Subject: METROWEST DCO EXAMINATION – ISSUE SPECIFIC HEARING 3 (ENVIRONMENTAL MATTERS) – ENVIRONMENT AGENCY WRITTEN RESPONSE TO AGENDA ITEM 5 (FLOOD RISK, DRAINAGE AND CONTAMINATED WATERS)

Our ref: WX/2019/133441/01-L09
Your ref: TRO40011
Date: 10 January 2021

**METROWEST DCO EXAMINATION – ISSUE SPECIFIC HEARING 3
(ENVIRONMENTAL MATTERS) – ENVIRONMENT AGENCY WRITTEN RESPONSE
TO AGENDA ITEM 5 (FLOOD RISK, DRAINAGE AND CONTAMINATED WATERS)**

Figure N-25: Pre Development, 75year return period event in 2115 ,Tidal

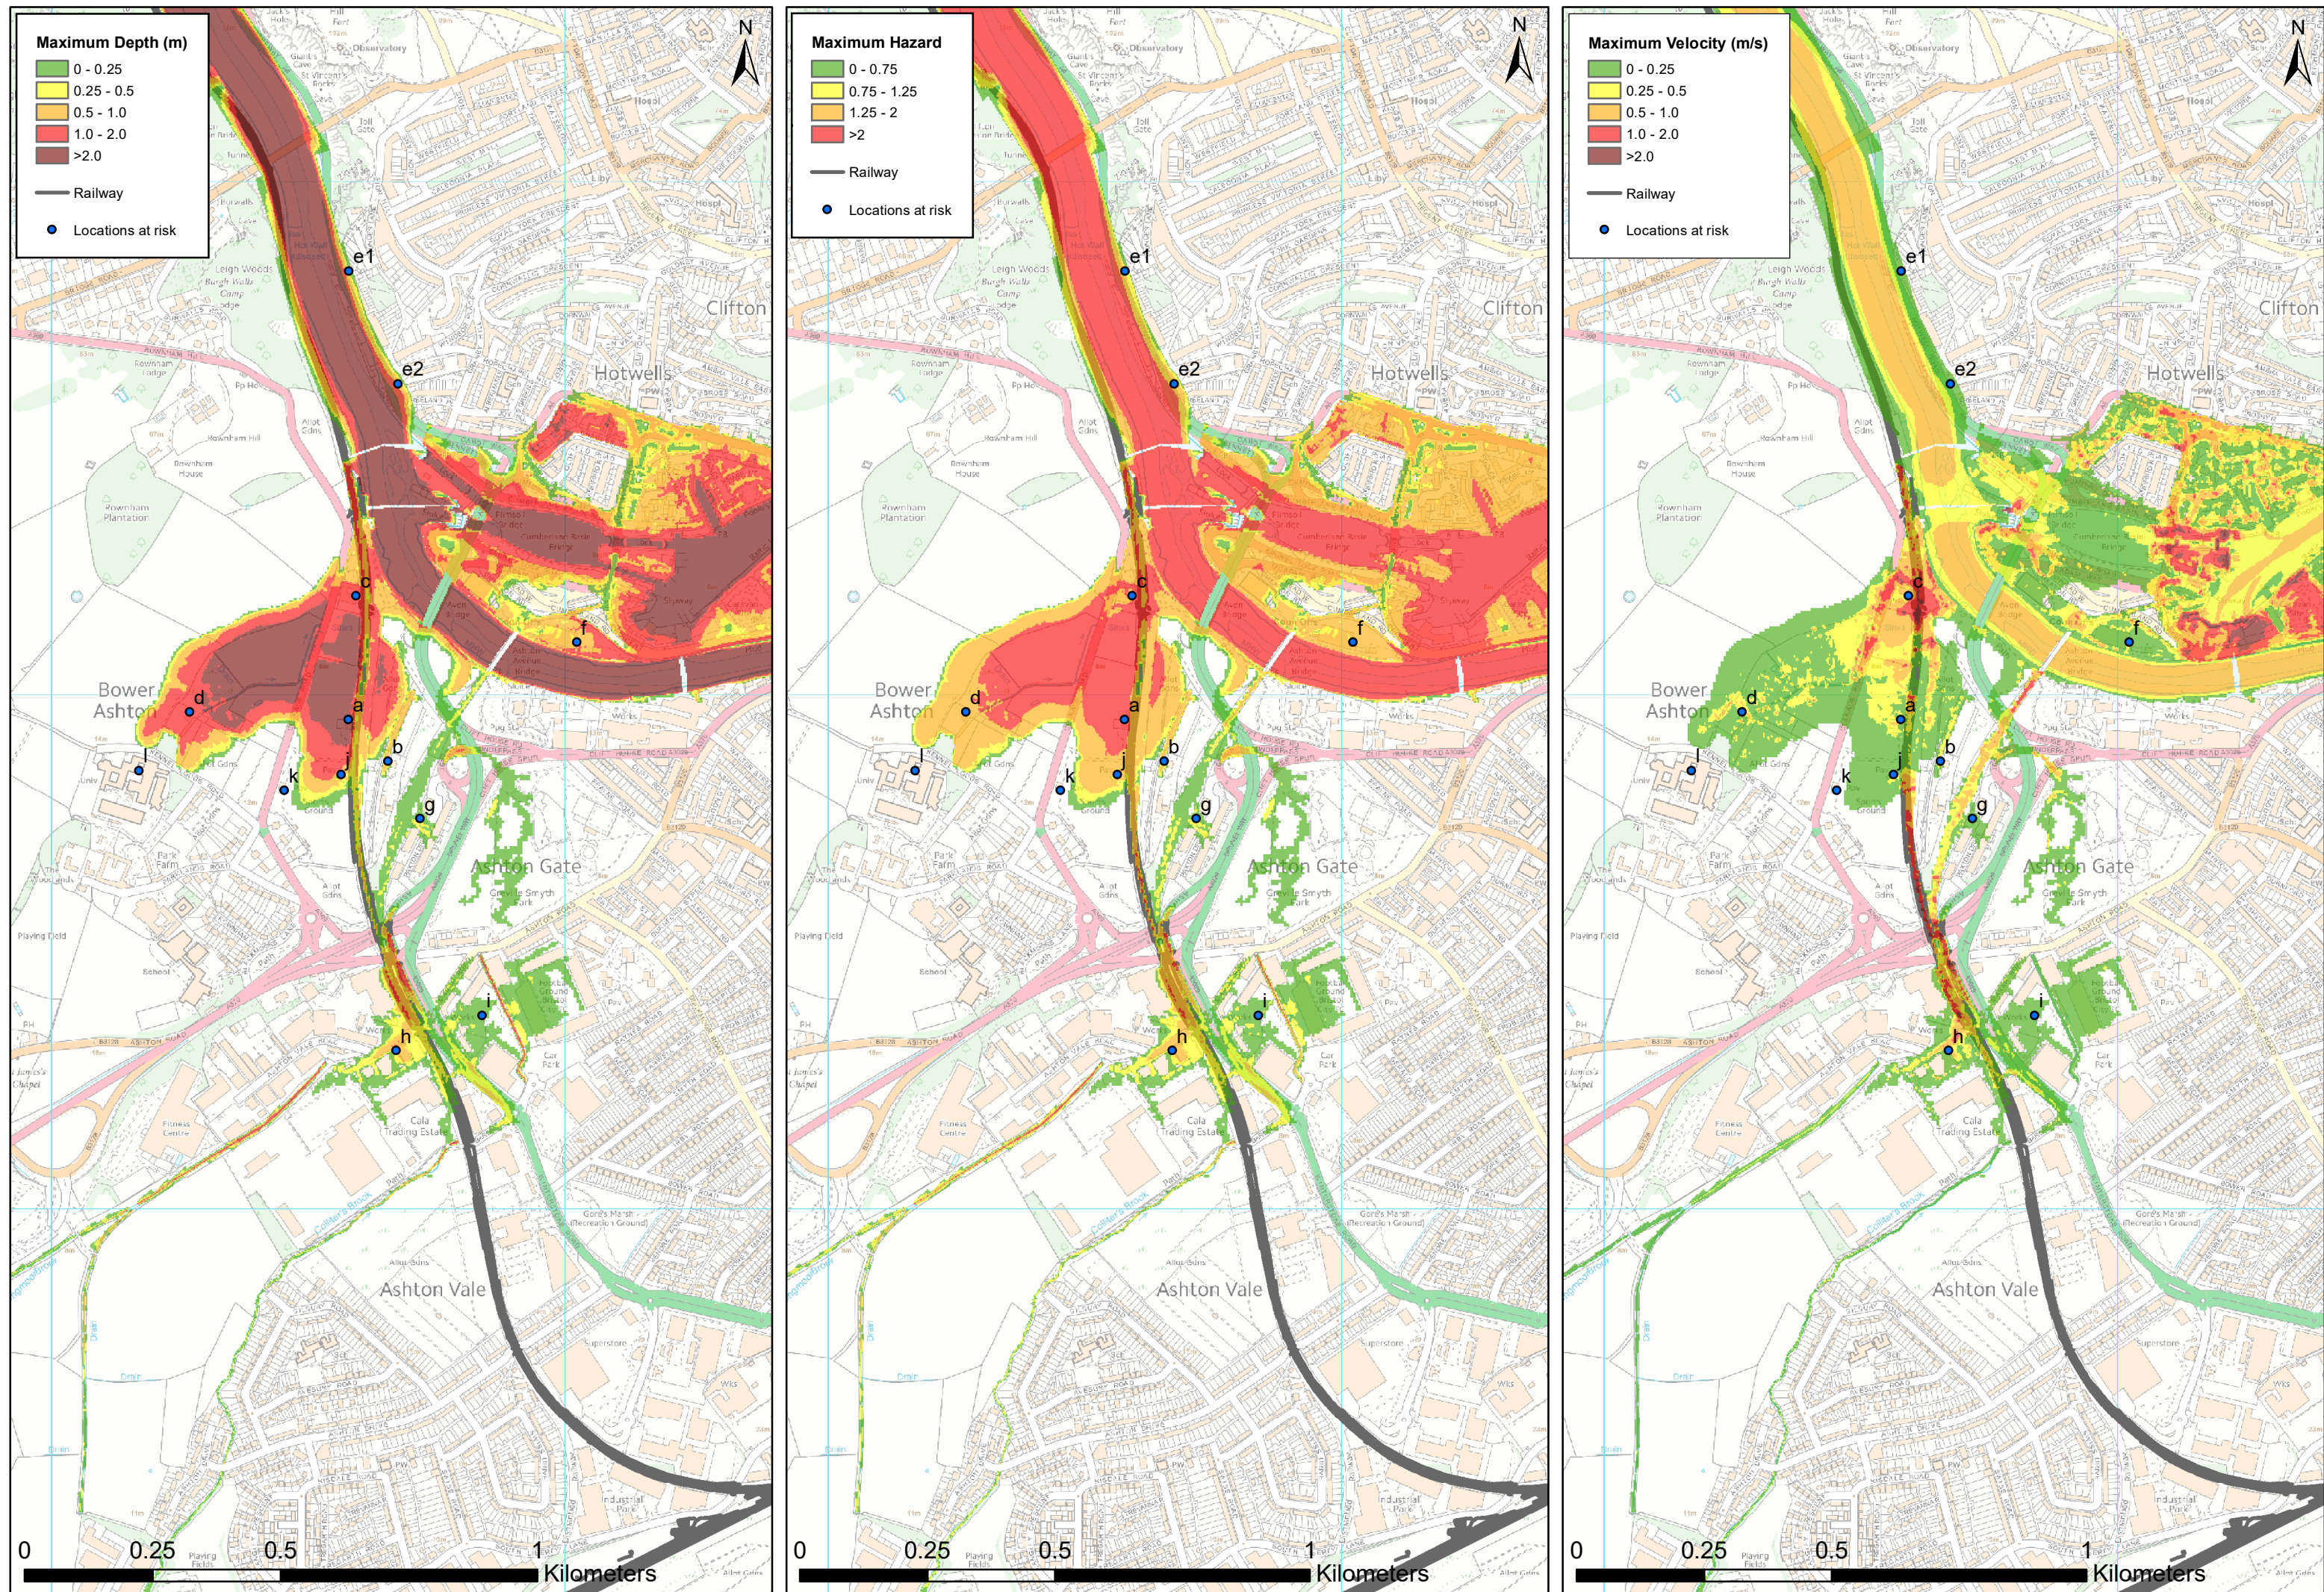
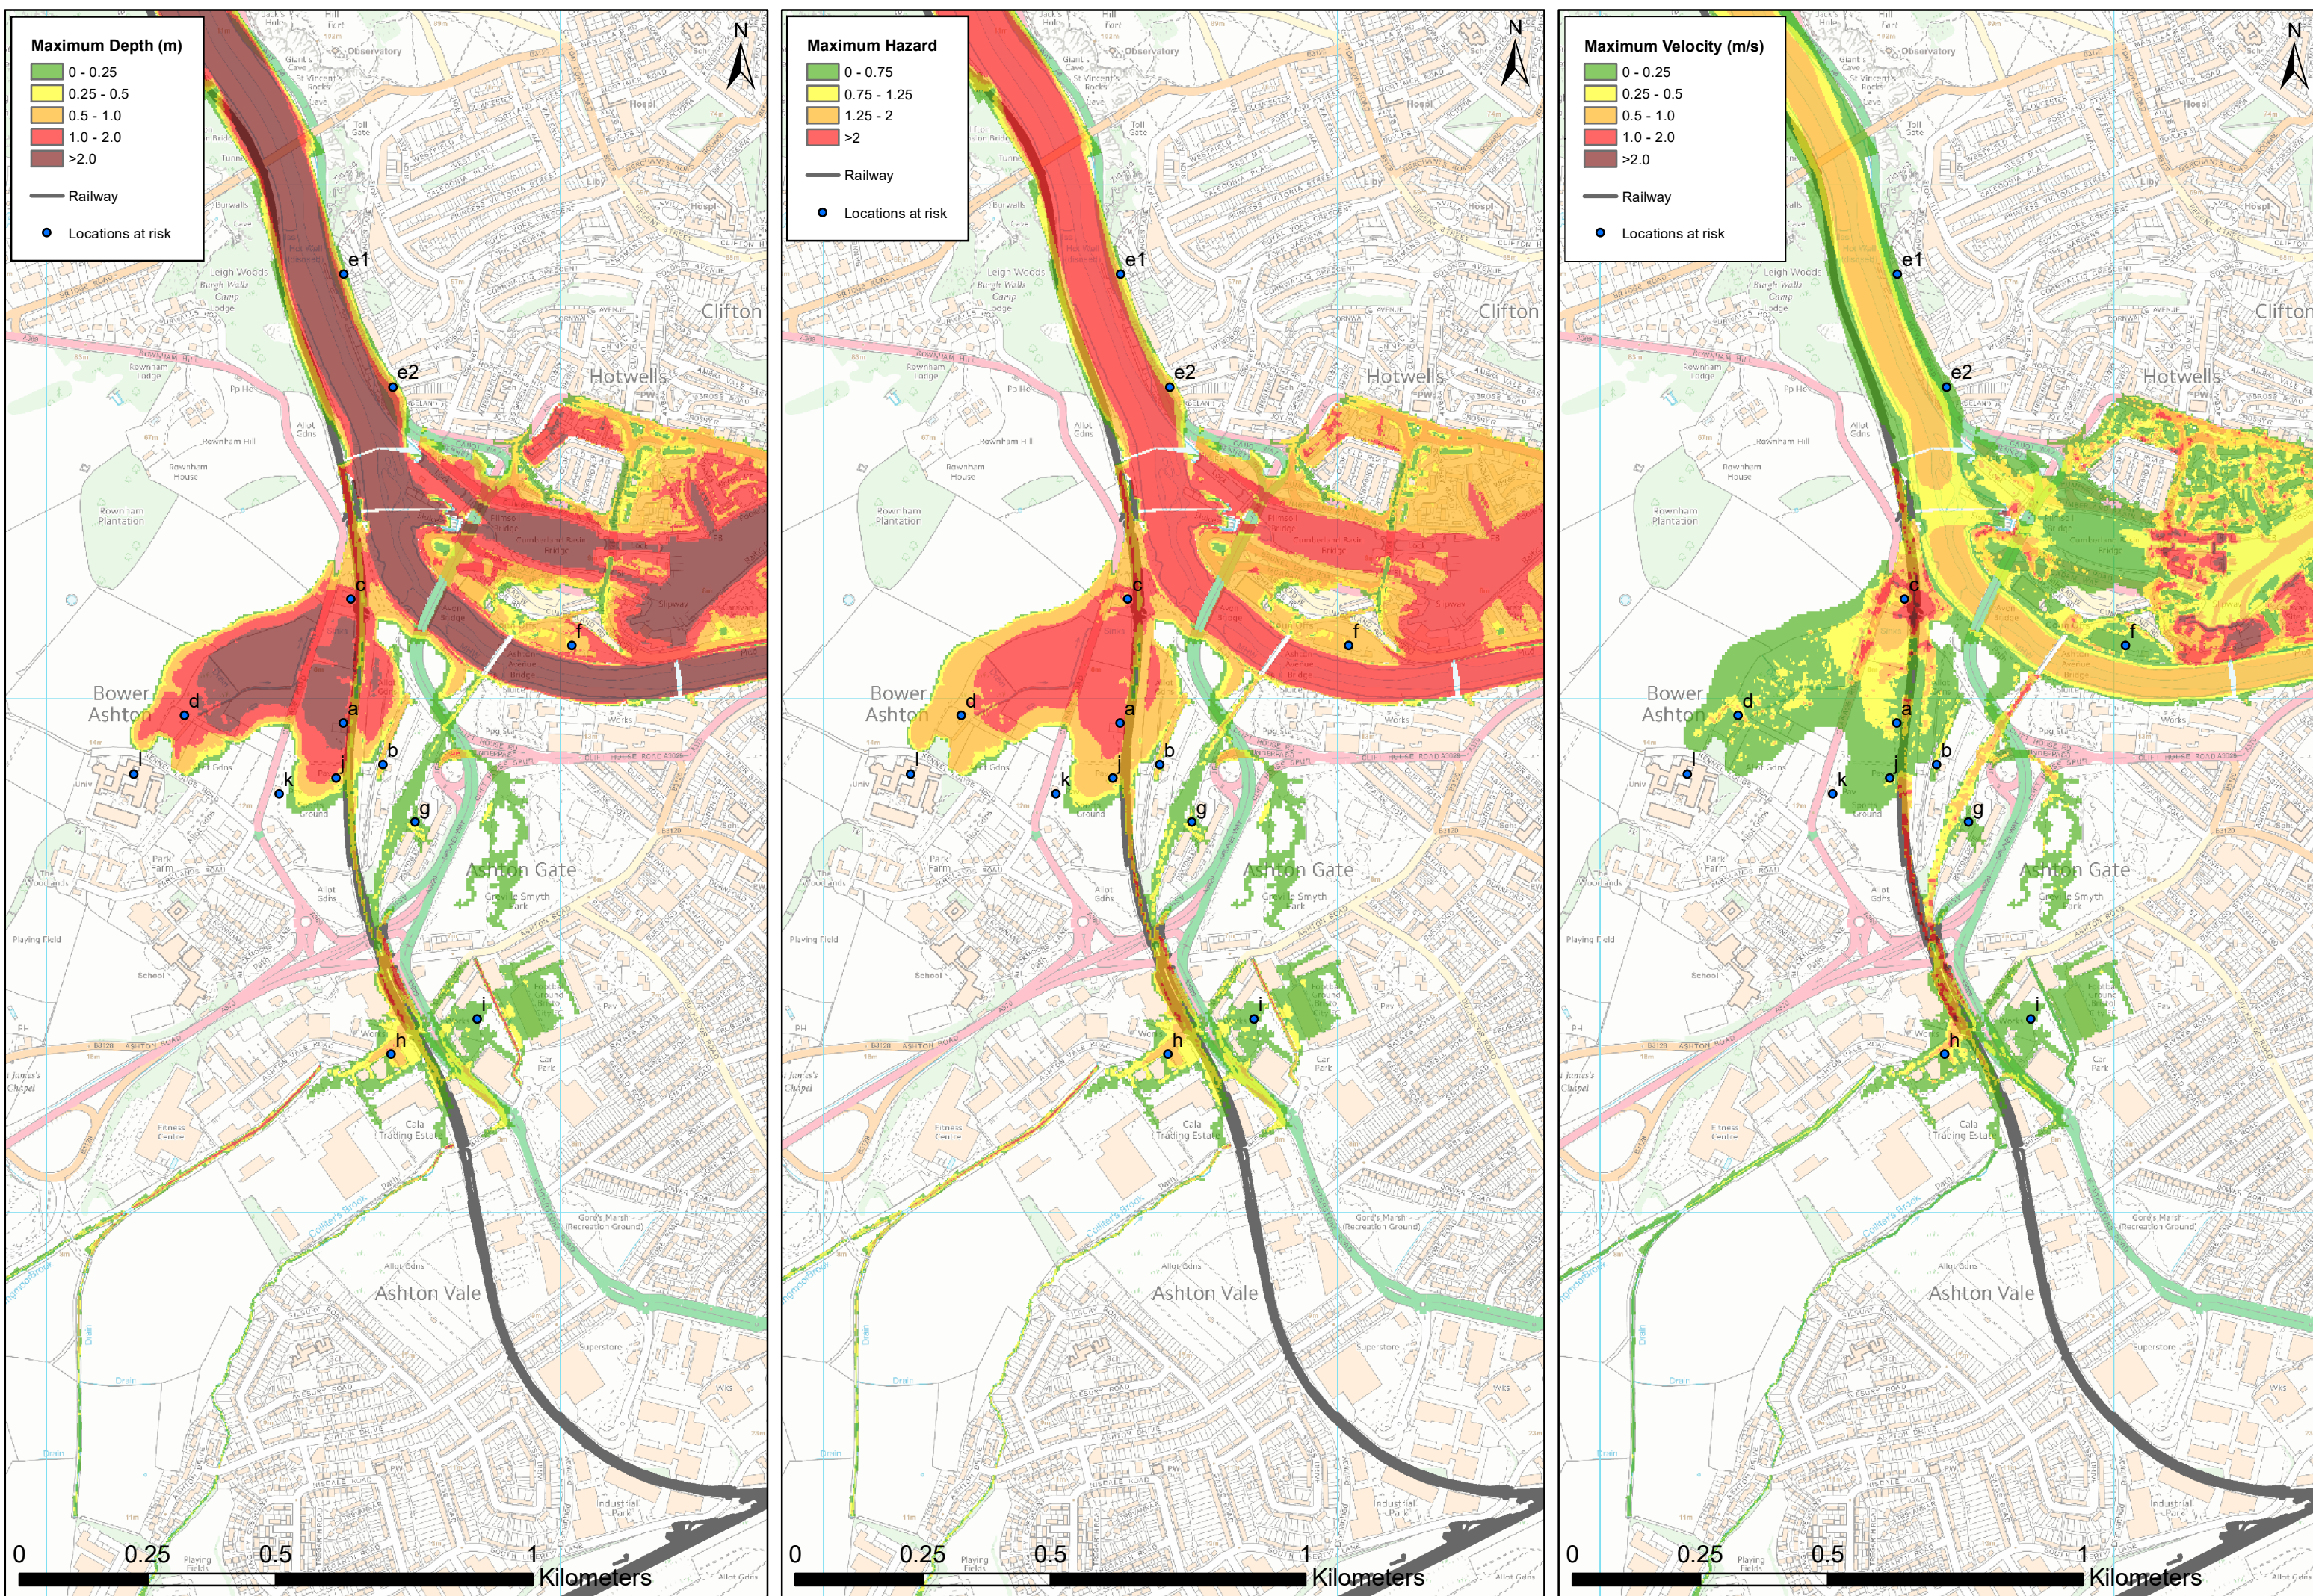
The Flood Risk Assessment (FRA) submitted in support of the proposal, has demonstrated that part of the site is in functional floodplain (Flood Zone 3b) and will, as a consequence, flood at a return period as low as 1 in 5 years at present. With the predicted impact of climate change, the frequency of flooding (and flood depth) increases to a potential 5 times a year in 2115.
